**Carters Yard, Main Street, Sibford Gower, OX15
5RW**

21/00559/F

Proposal: Conversion of garage building and erection of a single storey extension,
to form a granny annexe

06D

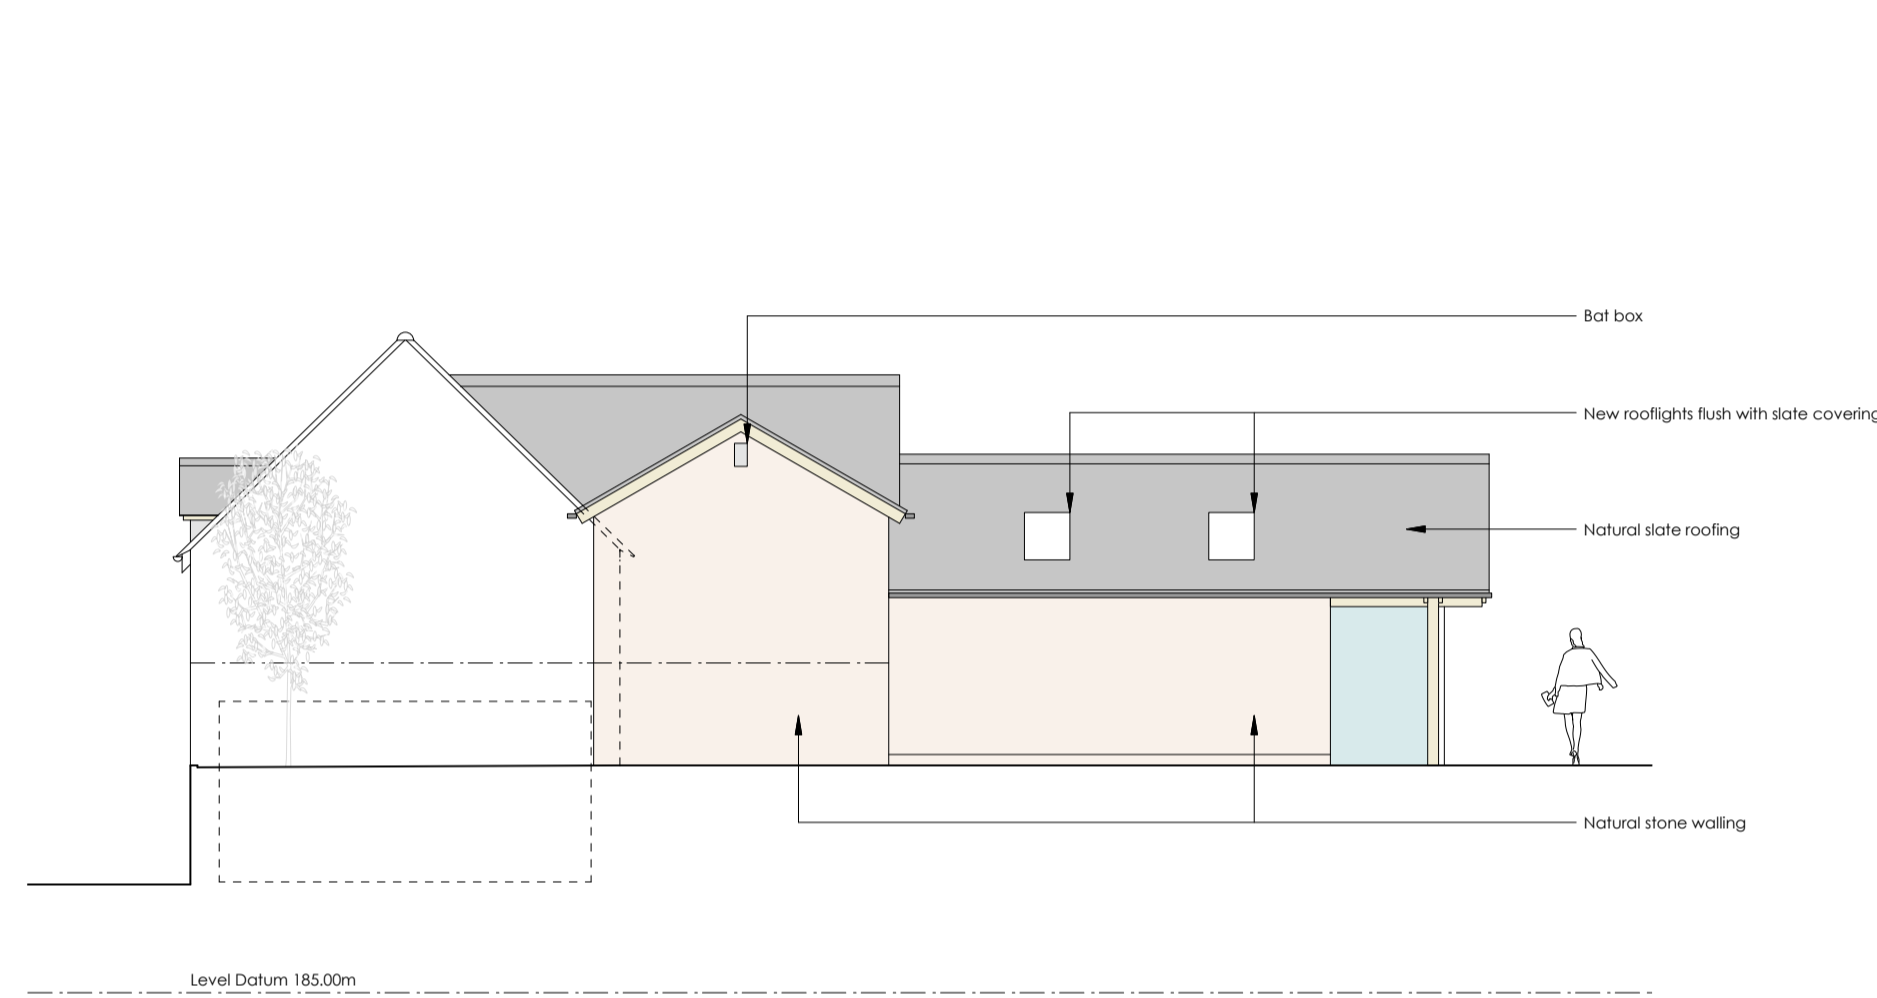
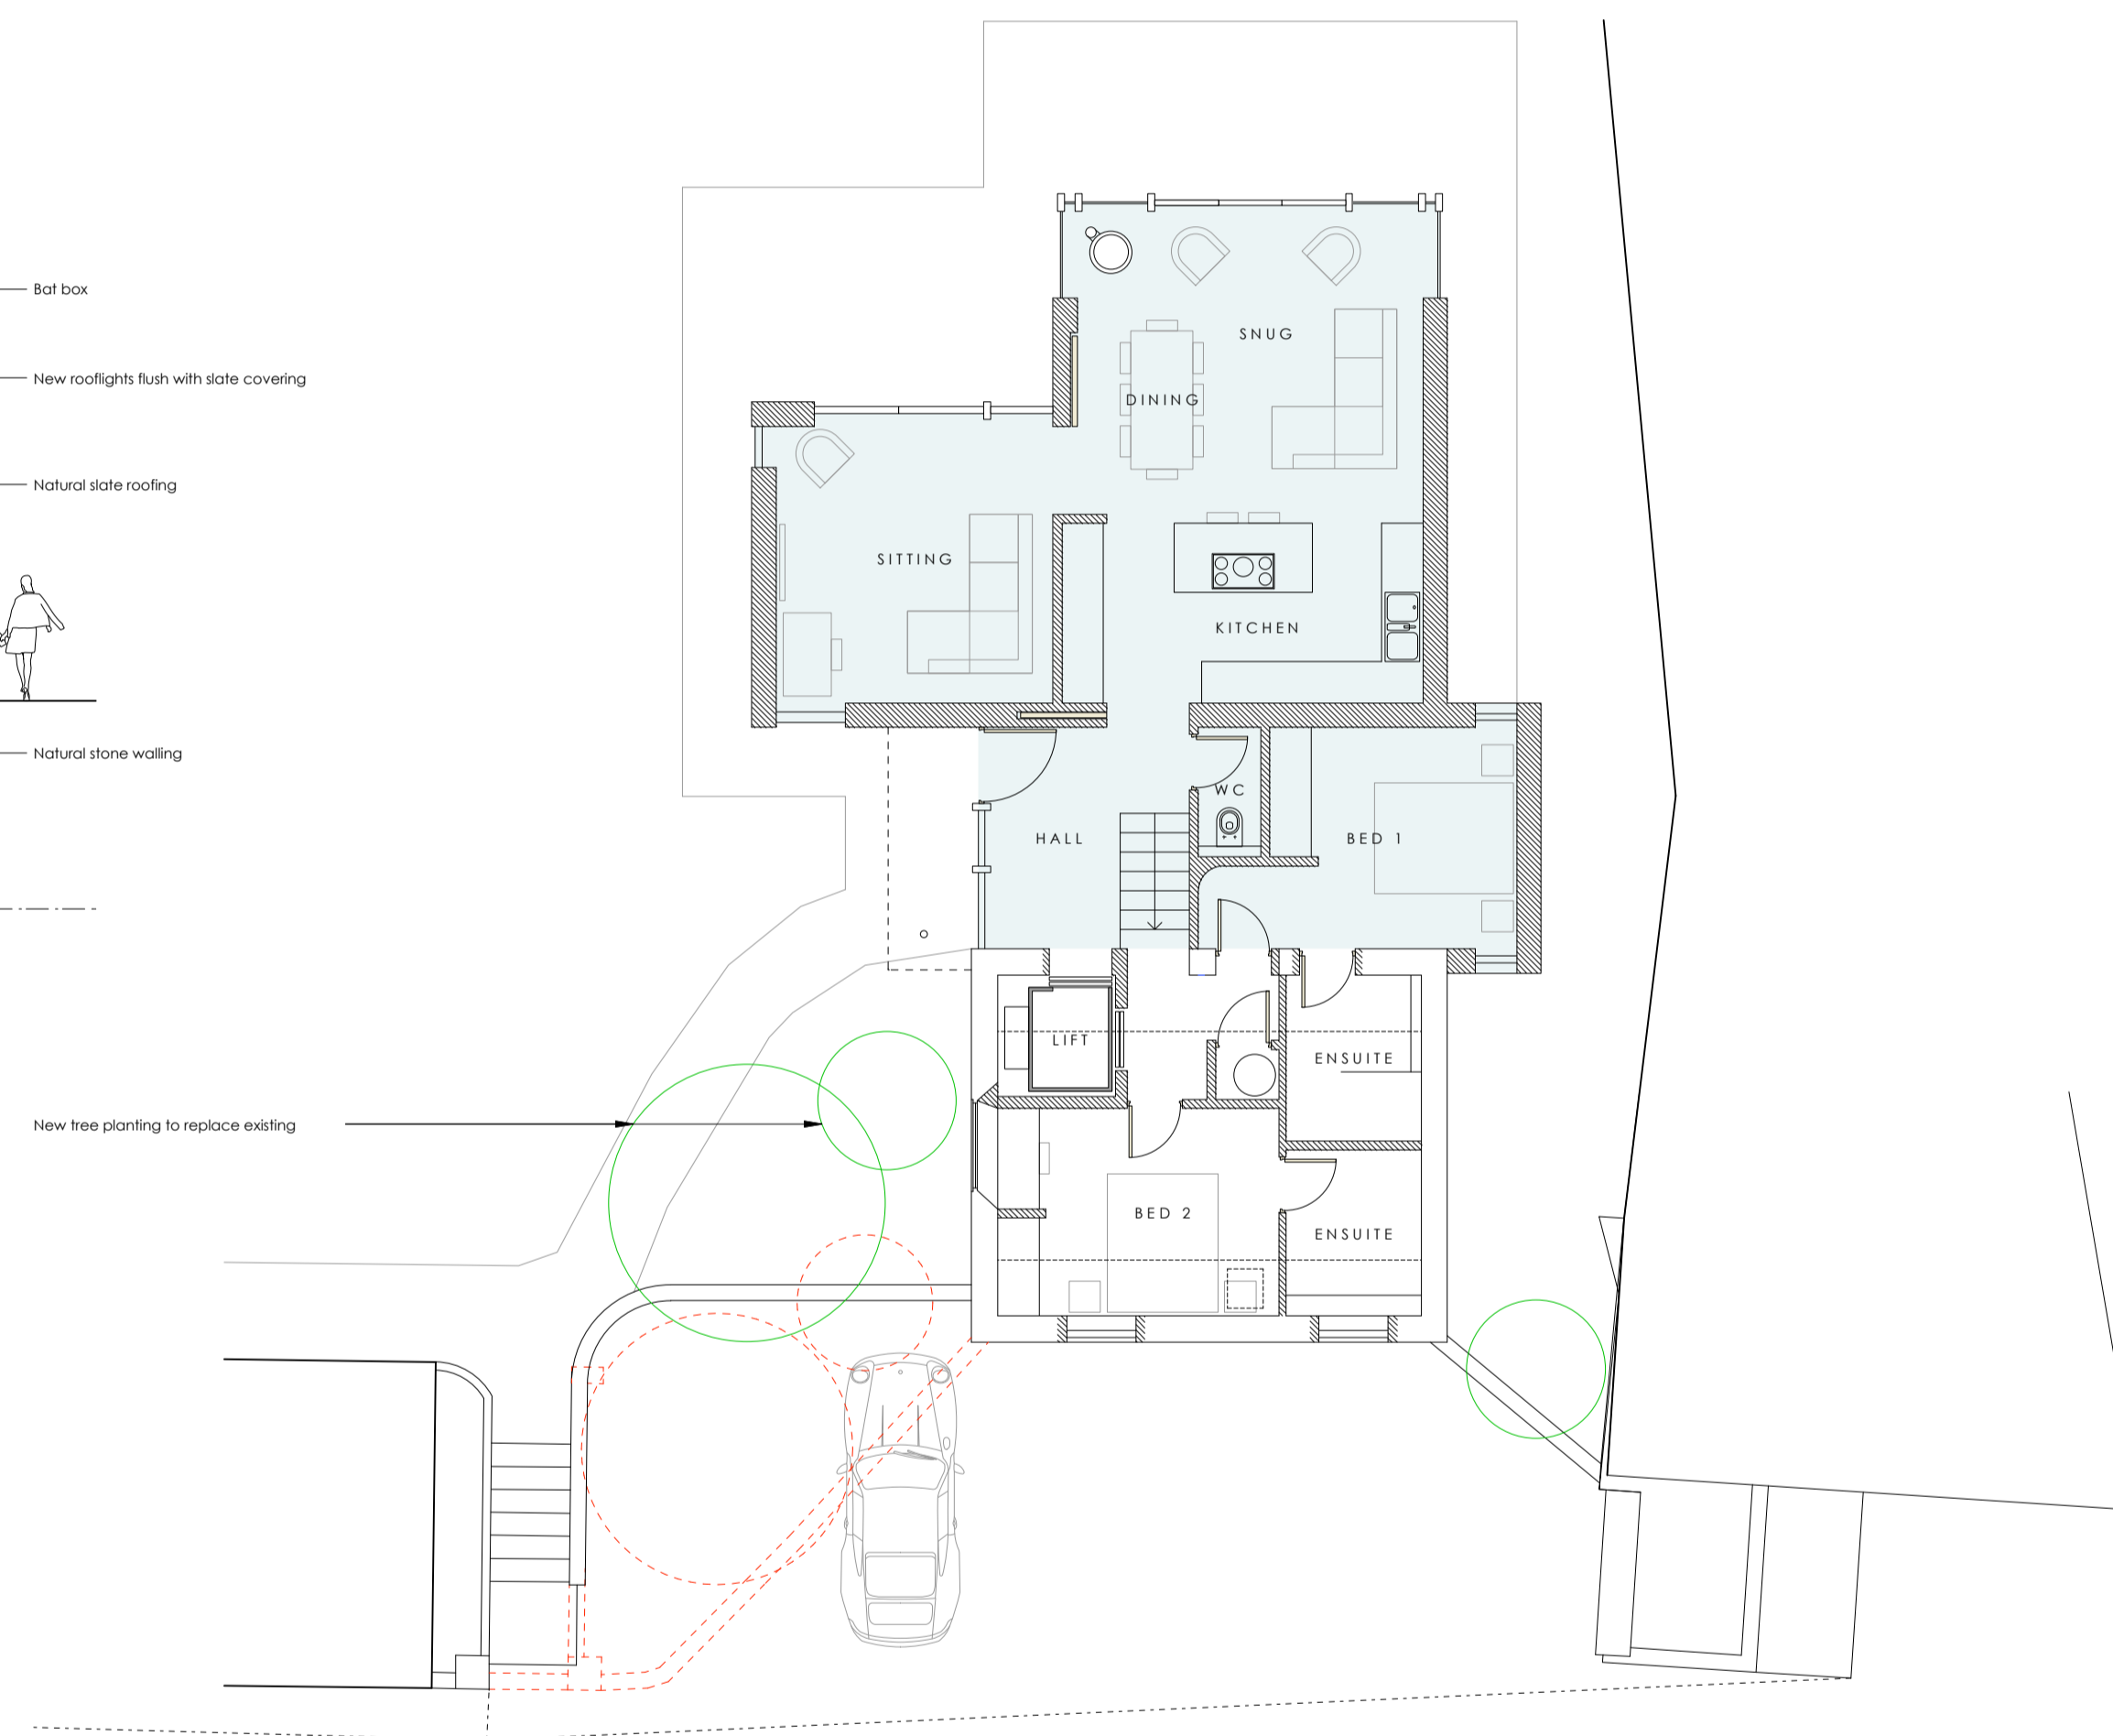
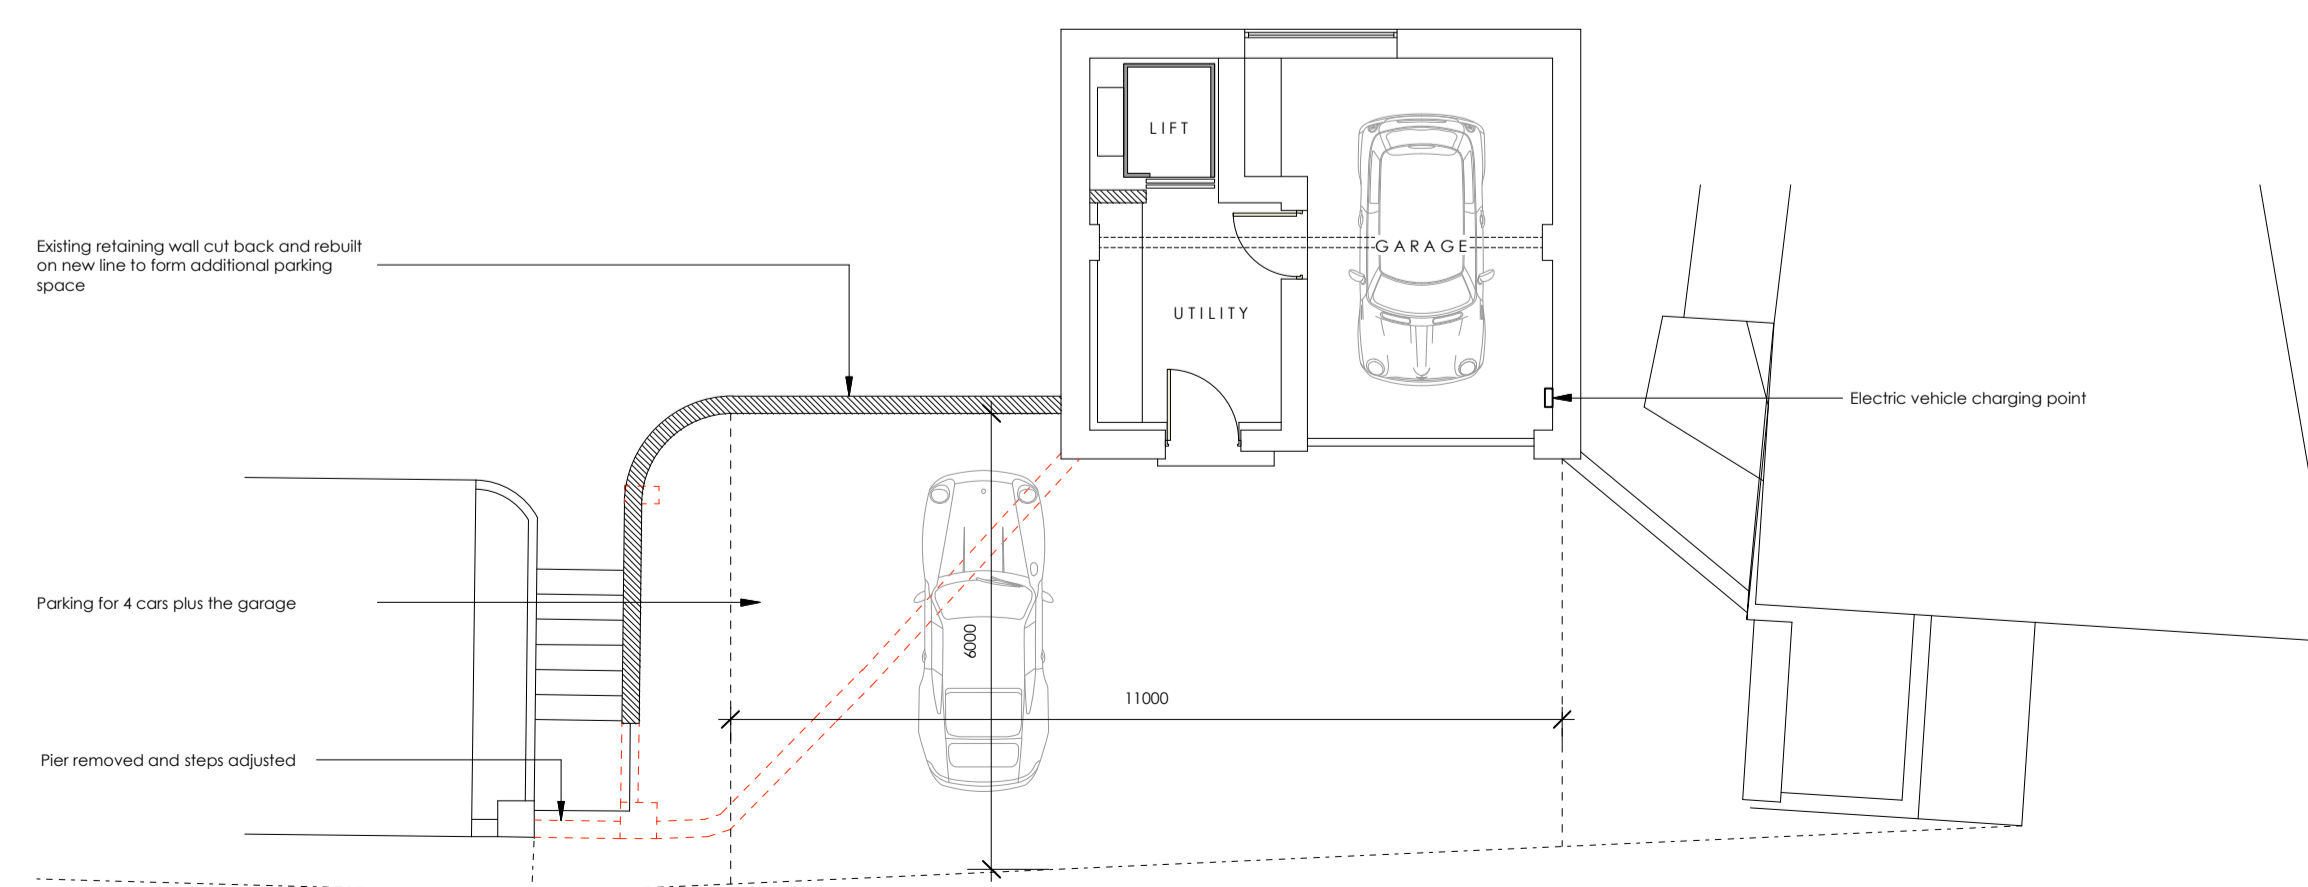
The proposed development would involve a single storey extension off the rear of the first floor element of the garage that has an overall height subservient to the existing structure. A variety of roof heights and styles, and projecting gables, break up the elevations and add interest. The extension is contemporary in appearance with full length glazed openings.

At pre-application stage I raised concern with regard to the proposed side projections, as they would unbalance the structure when viewing from the public domain although I note that the Conservation Officer does not consider this to be the case. Whilst I continue to have concerns, given the choice of construction materials, the set back from the road and the proposed replacement landscaping, I do not consider that I could defend the refusal of the application on the grounds of visual impact at appeal.

The proposed dormer windows and rooflight would be positioned less than 22 metres from the frontage of Manor House (approx. 19m), although given that these are both the less private frontages I do not consider that they would result in a significant loss of amenity for either resident.

Client	Mr + Mrs M. Bannister	
Project	Carters Yard Sibford Gower	
Drawing	Proposals	
	Sketch Site Plan 2	
Date	Sept 20	
Scale	1:100 at A1	SH
Job No	20-002	Drawing No 07C

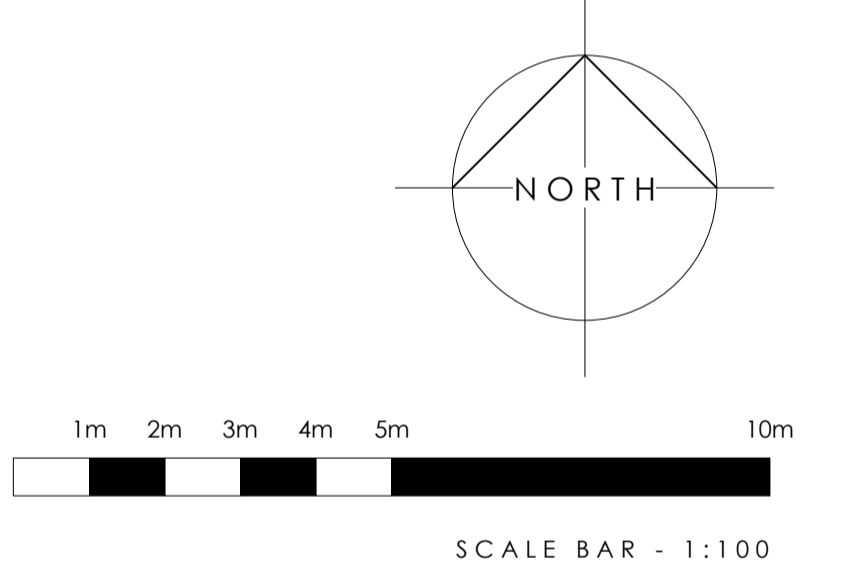
The existing dry stone wall would be repositioned to accommodate the additional parking, which is preferable to the complete loss of the wall.

Concerns were raised by the Highway Authority regarding the impact of the development upon highway safety at both pre-application stage and during the consideration of the current application. In summary, these related to the limited visibility, parking bay dimensions, additional parking in the public highway, insufficient parking provision and construction related constraints.

The Highway Authority have since re-assessed the proposal taking the supporting Highway and Access Technical Note into consideration. Following this assessment, the Highway Authority has agreed with the conclusion with regard to visibility and advised that they do not consider that they could demonstrate such harm that would warrant the refusal of the application for reasons of highway safety and convenience. One of the reasons behind this change in stance is that the application had originally been assessed as the creation of a new two bedroom dwelling, as opposed to the addition of one bedroom to existing ancillary accommodation as is proposed (requiring only 1 extra space that is provided).

8. Prior to the first occupation of the development hereby approved, the parking and manoeuvring areas shall be provided in accordance with the plan approved (20-002 06D) and shall be constructed from porous materials or provision shall be made to direct run-off water from the hard surface to a permeable or porous area or surface within the curtilage of the site. Thereafter, the parking and manoeuvring area shall be retained in accordance with this condition and shall be unobstructed except for the parking and manoeuvring of vehicles at all times.
